Question

Kippure Lodge and Holiday Village,
Kippure Estate, Manor Kilbride,
Blessington, County Wicklow.

Wicklow County Council

EX53/2024

Structure 05

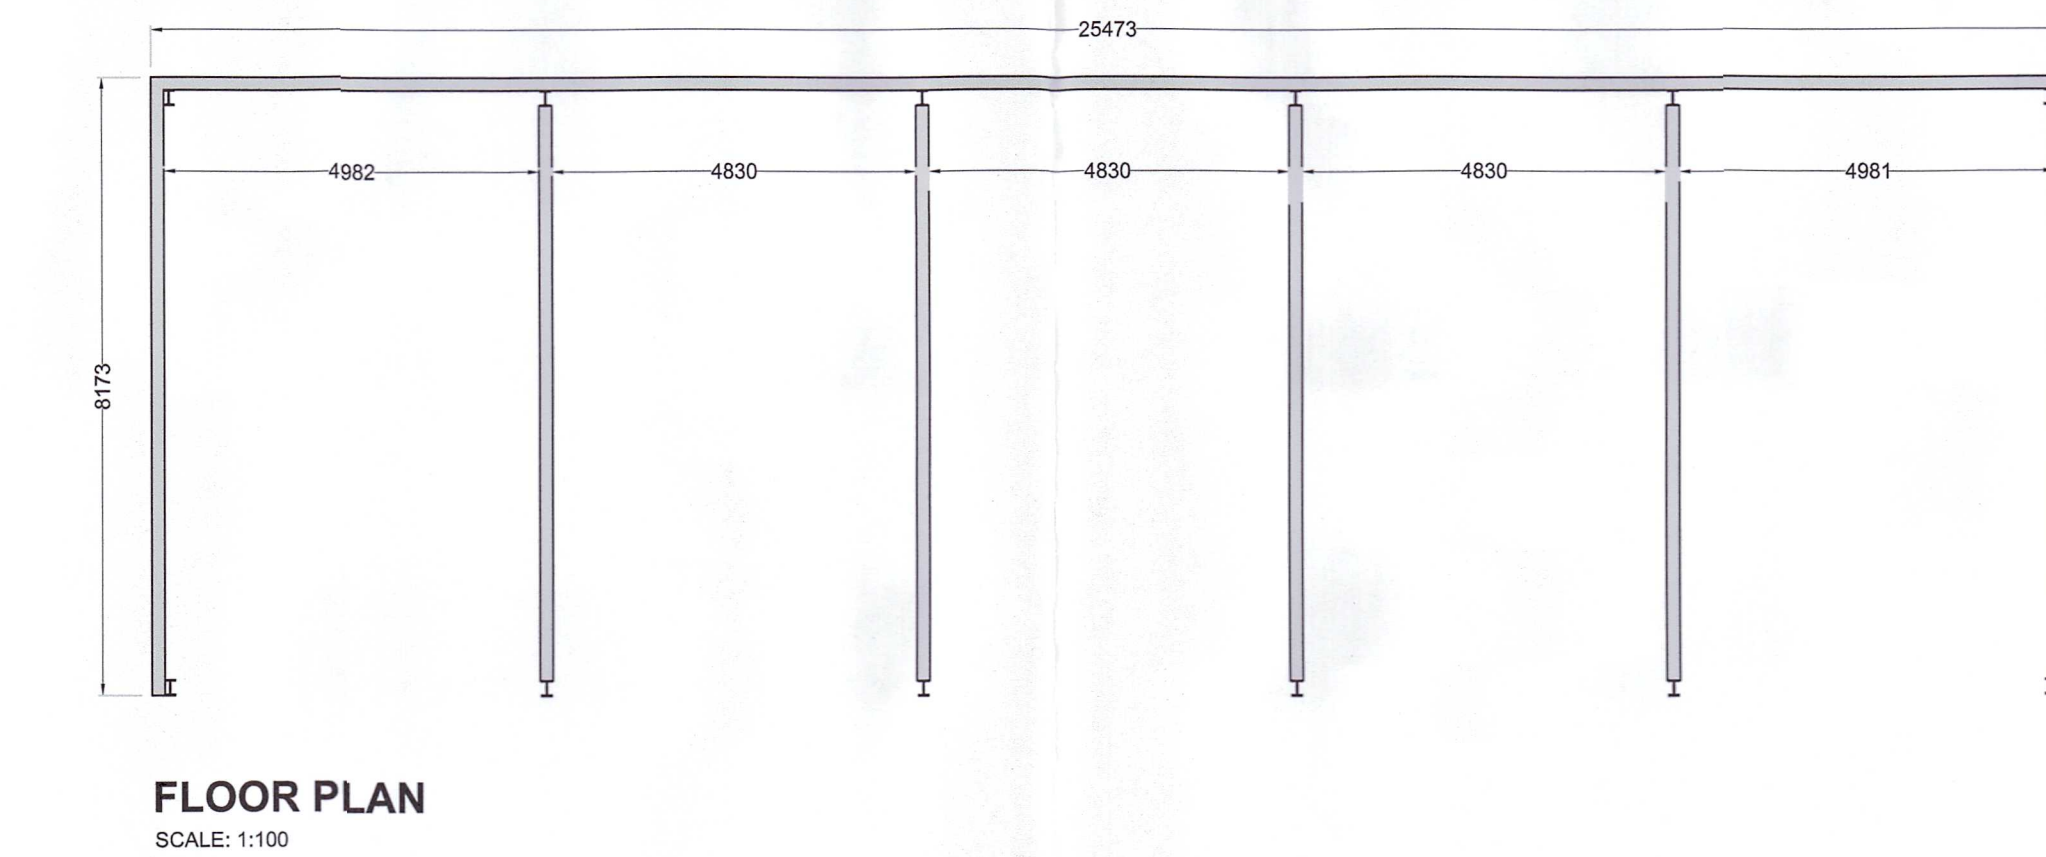
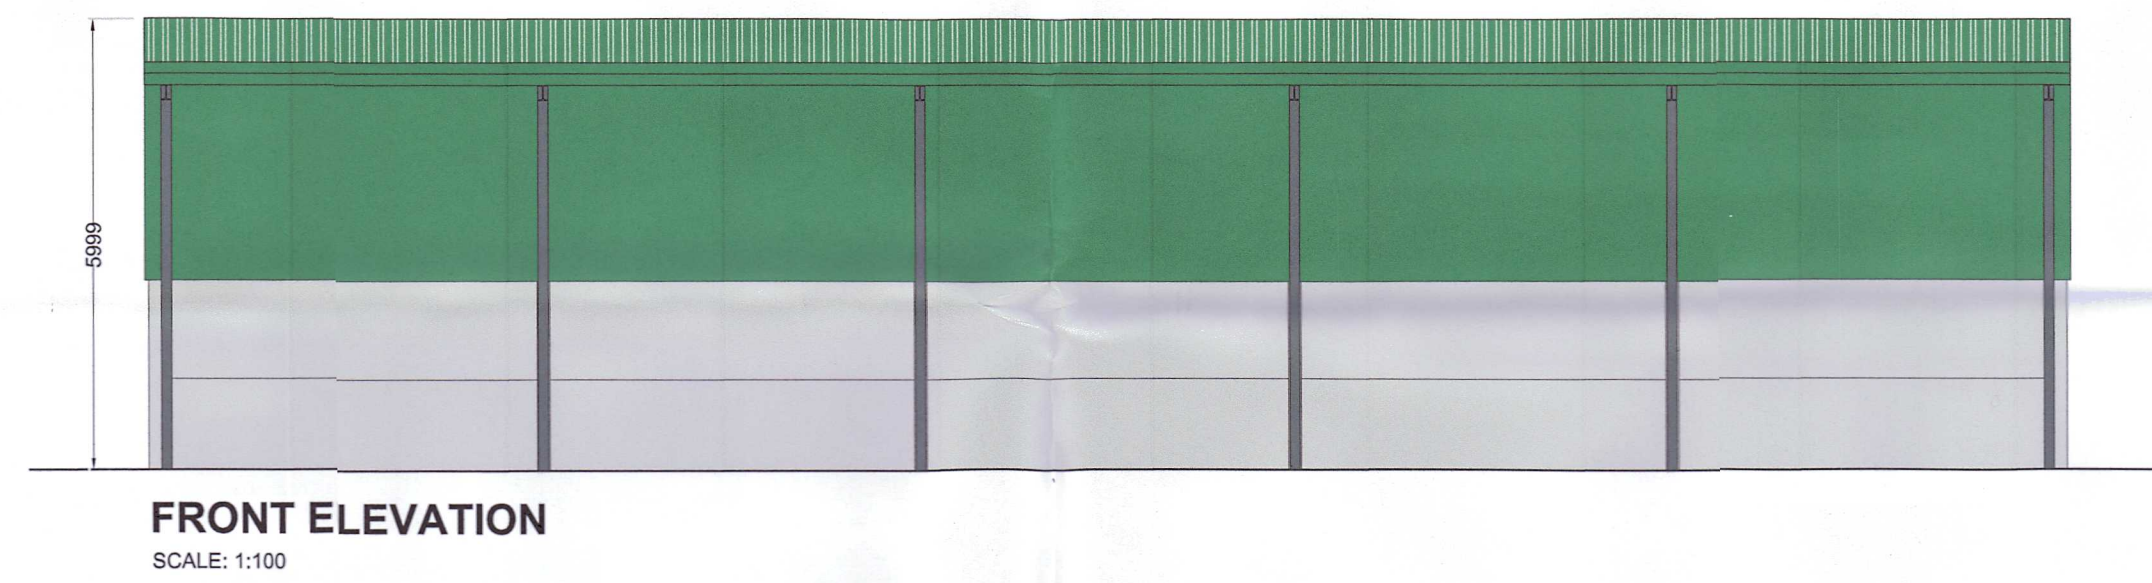
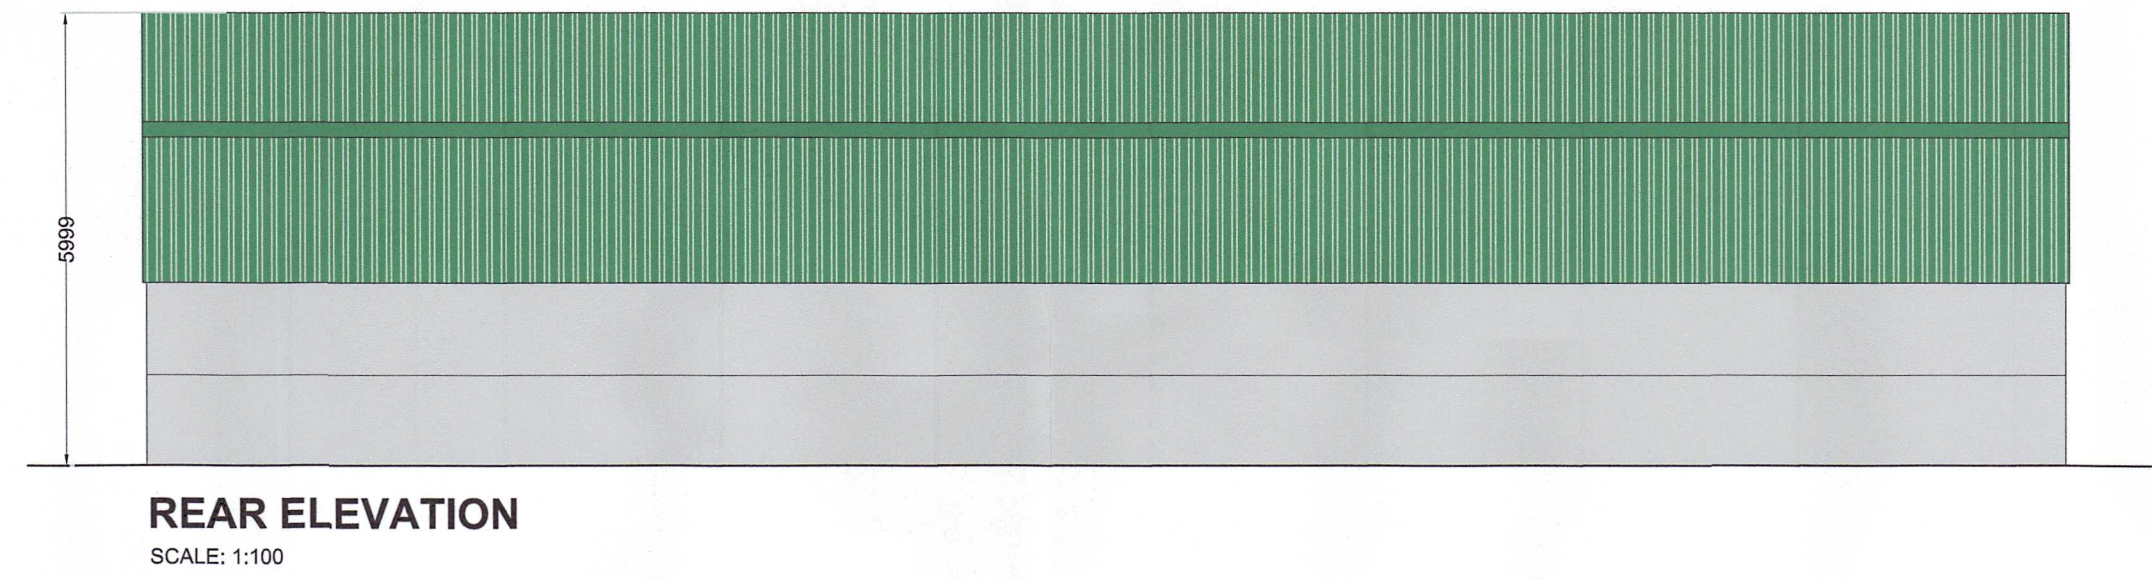
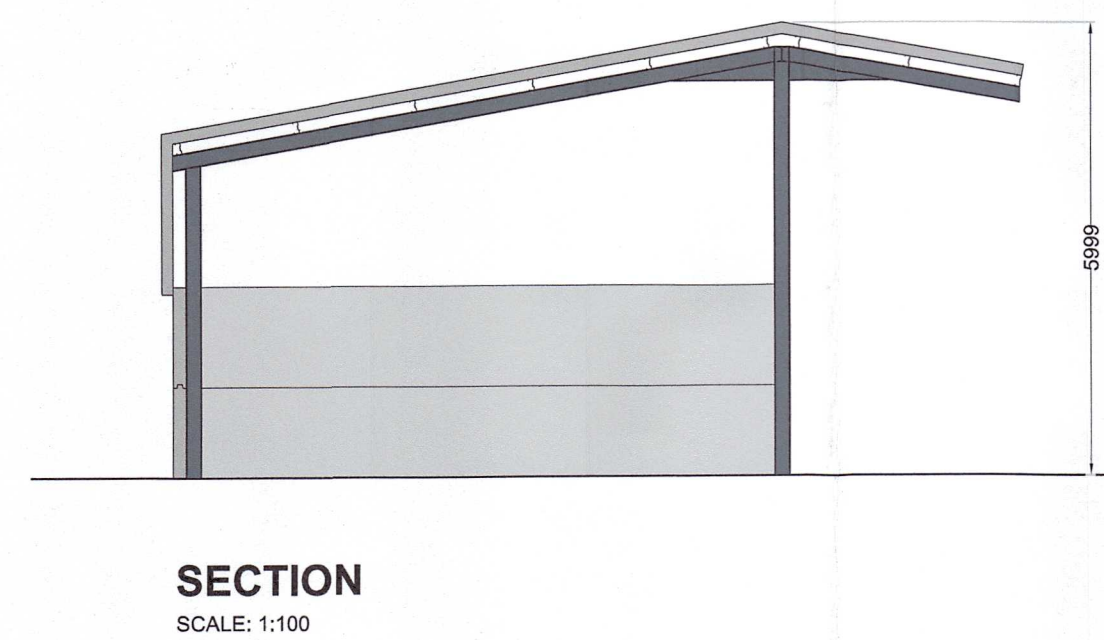
It would appear from aerial photography that this structure was constructed after March 2022. The structure comes within the meaning of works and would therefore come within the meaning of development as provided for in Section 3(1) of the PDA.

Class 9 of Part 3 of Schedule 2 provides an exemption for any store, barn, shed, glass house or other structure, having a gross floor area (GFA) not exceeding 300sqm. The structure has a GFA of 208sqm.

- The use can be considered as part of the overall maintenance of agricultural areas not dedicated to the Kippure Holiday Village.
- Structure no. 2 and 6 were completed prior to this structure and have an overall area of 1,134 sqm and would exceed the aggregate 900sqm limitation.
- The structure is in excess of 10m from the public road.
- The structure is not within 100m of any house.
- Metal sheeting on the structure is painted.

The structure would not come within the provisions of Class 9 and therefore is not exempted development.

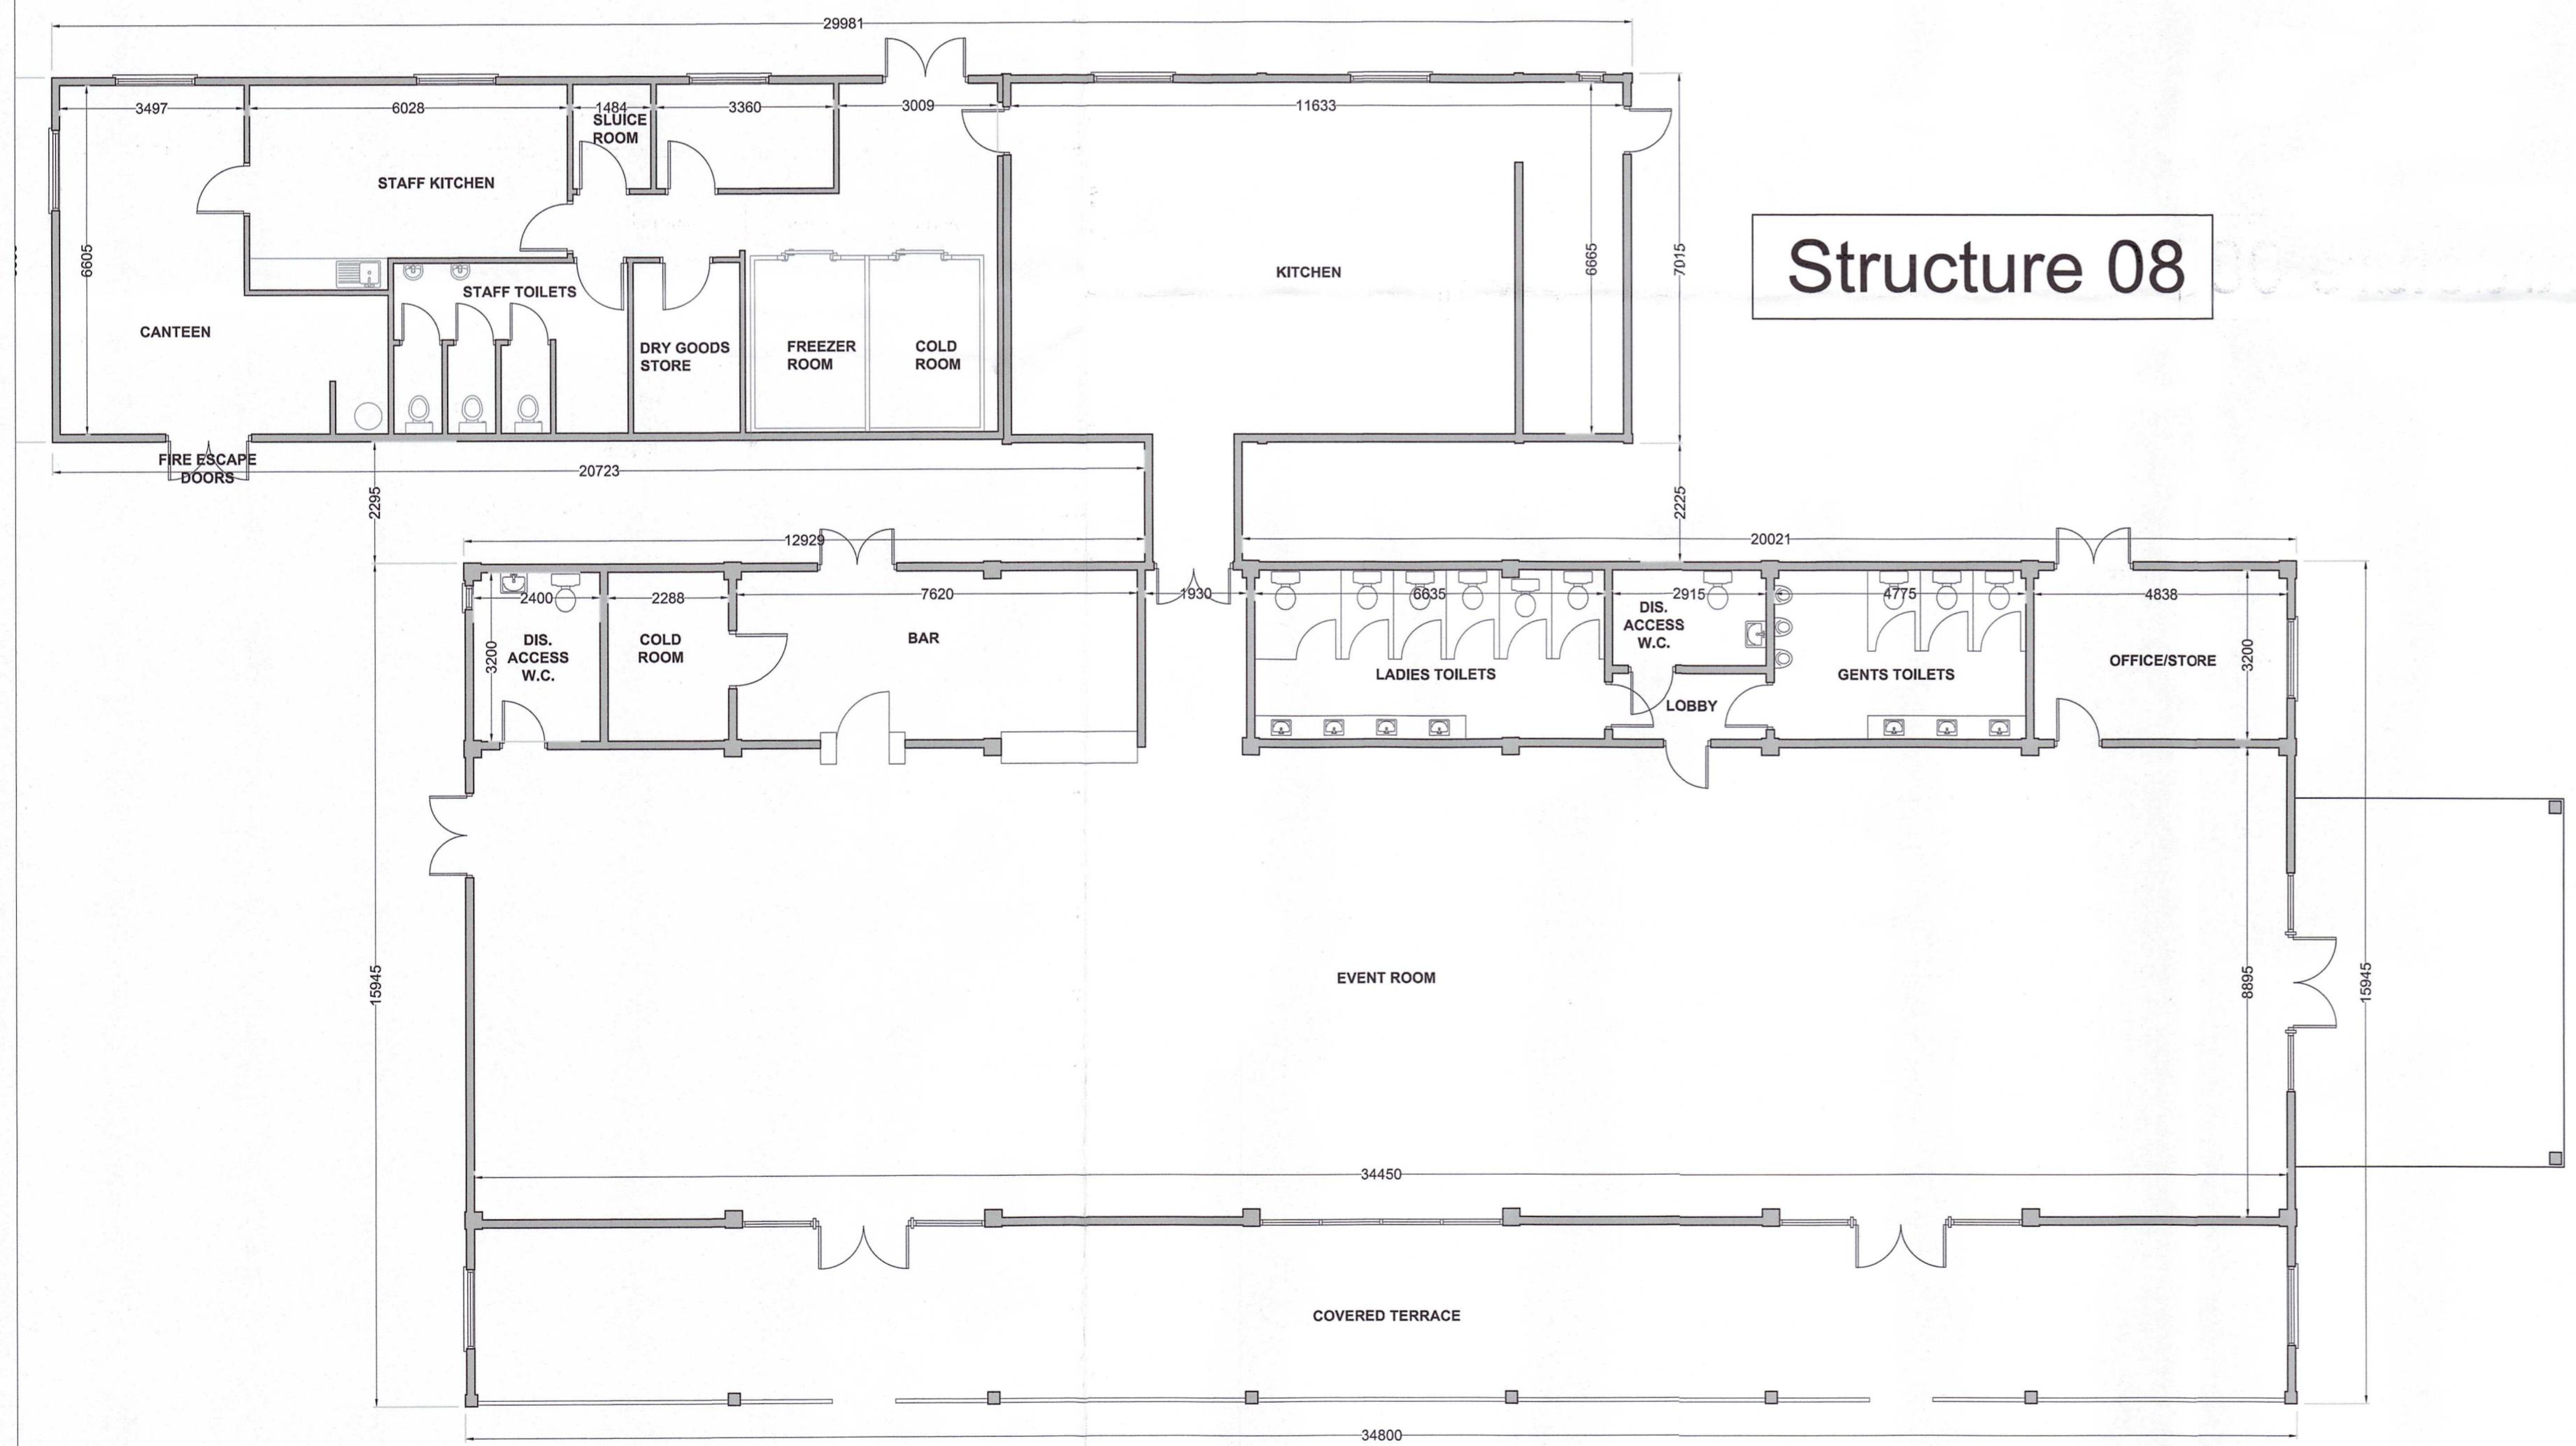
Structure No 7 and No. 8 are interlinked. The reference to this building being permitted under Reg. Ref. 17/1335 is incorrect as this decision was overturned on appeal, ABP 300834-18.

The structure comes within the meaning of works and would therefore come within the meaning of development as provided for in Section 3(1) of the PDA. There are no exemptions in the PDR that would apply to Structure No. 7 and Structure No. 8.

There are no other exemptions available for these structures. Therefore, these structures are development and are not exempted development.
